State of Washington
DEPARTMENT OF FISH AND WILDLIFE

August 25, 2026

SUBJECT: WDFW COMMENTS ON SCHULTZ SHORT PLAT (SP-26-00007)

Critical Areas

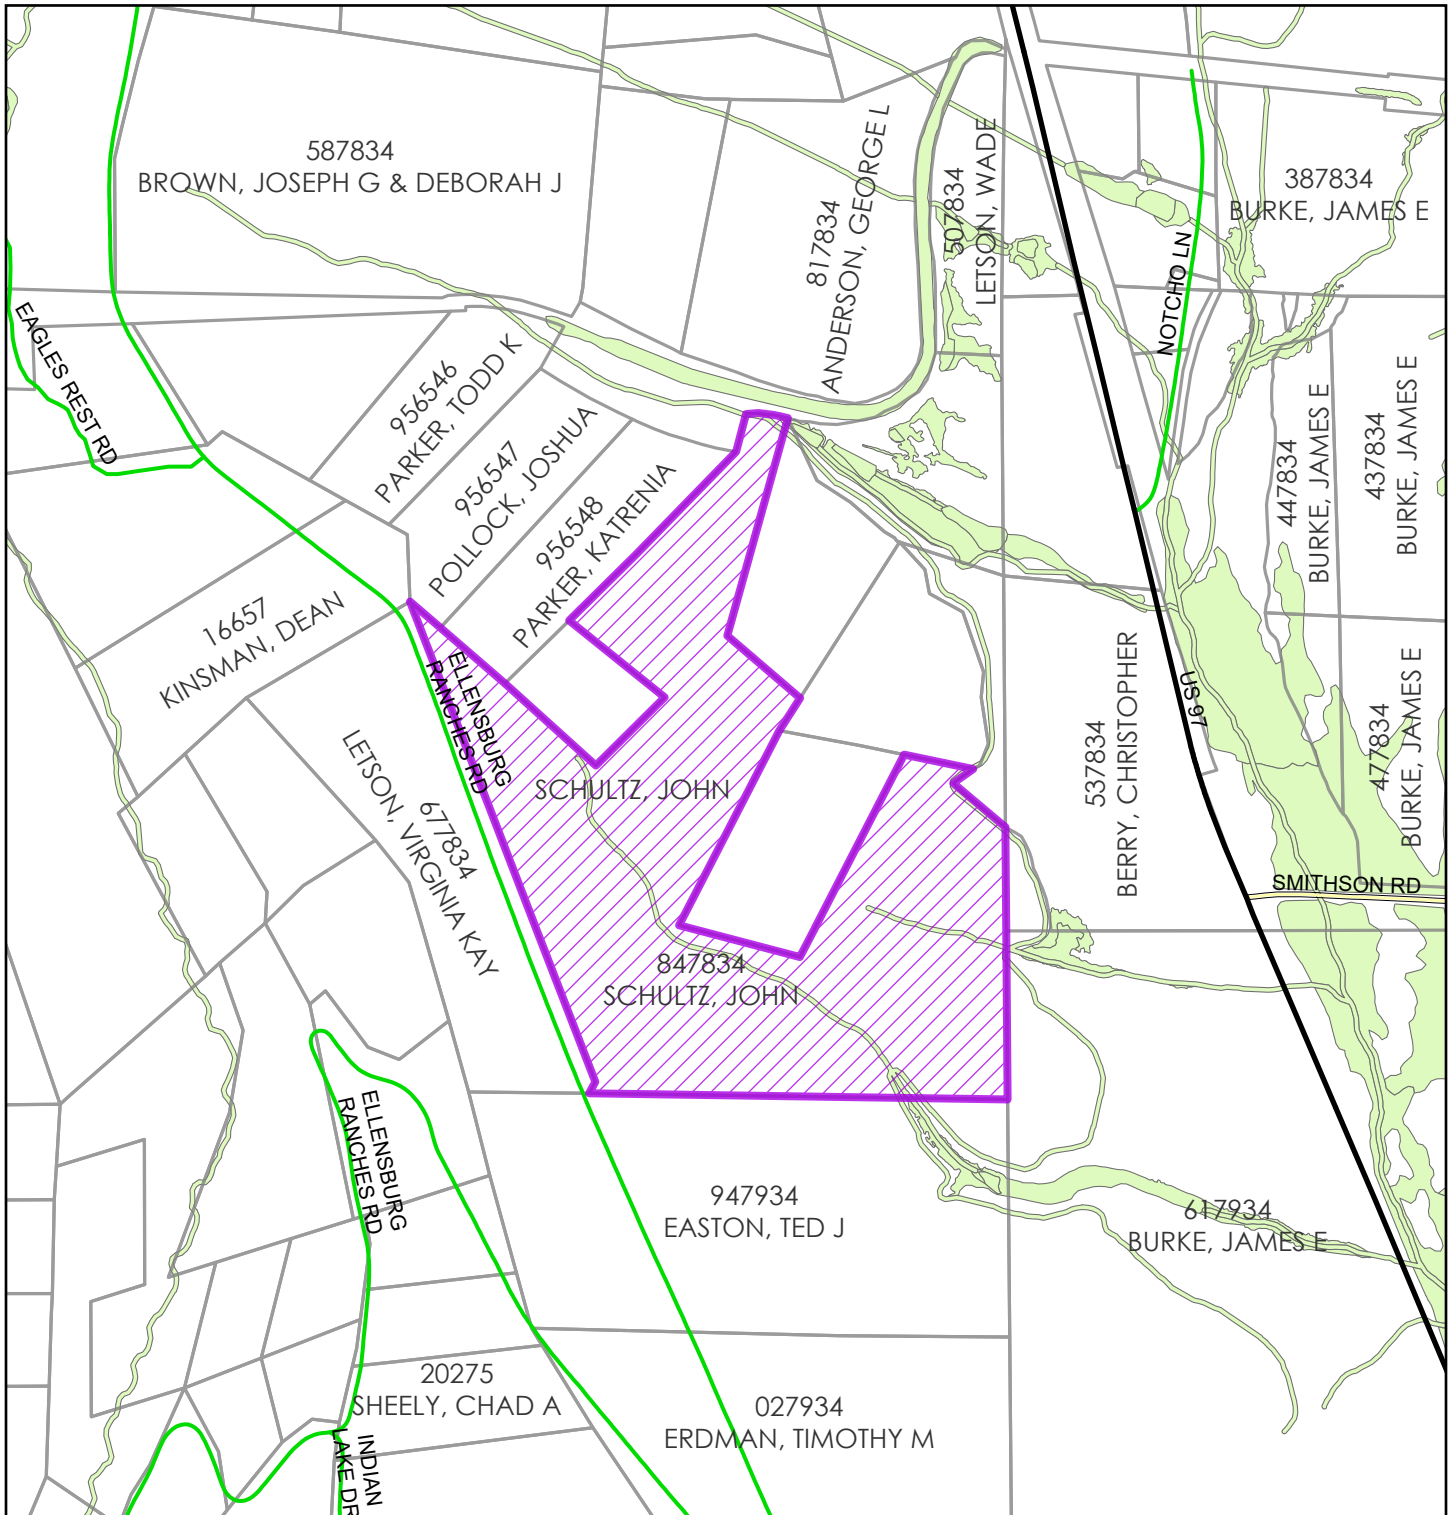
The parcel proposed for this short plat contains shrubsteppe habitat, is Mule Deer winter range habitat, and is located within a Biodiversity Area and Corridor; all are identified in WDFW's Priority Habitats and Species (PHS) program and are designated Fish and Wildlife Habitat Conservation Areas under Kittitas County's Critical Areas Ordinance (KCC 17A.04).

WDFW recommends that these critical areas be included in the Critical Areas Map provided with the application materials and/or as part of the final plat approval. Providing clarity now on the critical areas present will help ensure all future development proposals are aware of these critical areas and the appropriate mitigation measures will be applied to address any potential impacts to shrubsteppe habitat. We would encourage conservation platting to create buildable envelopes on each new parcel with the buildable areas clustered together to minimize disturbance of the critical areas. We would recommend that these building envelopes and impacts on the critical areas be determined prior to final approval of the plat to be consistent with mitigation sequencing in the Critical Areas Ordinance. WDFW is willing to meet with the applicant to provide suggestions on the clustering of the building envelopes to minimize impacts to the critical areas, particularly wildlife movement. All future development on these lots should follow mitigation sequencing to minimize disturbance and mitigate for the unavoidable impacts.
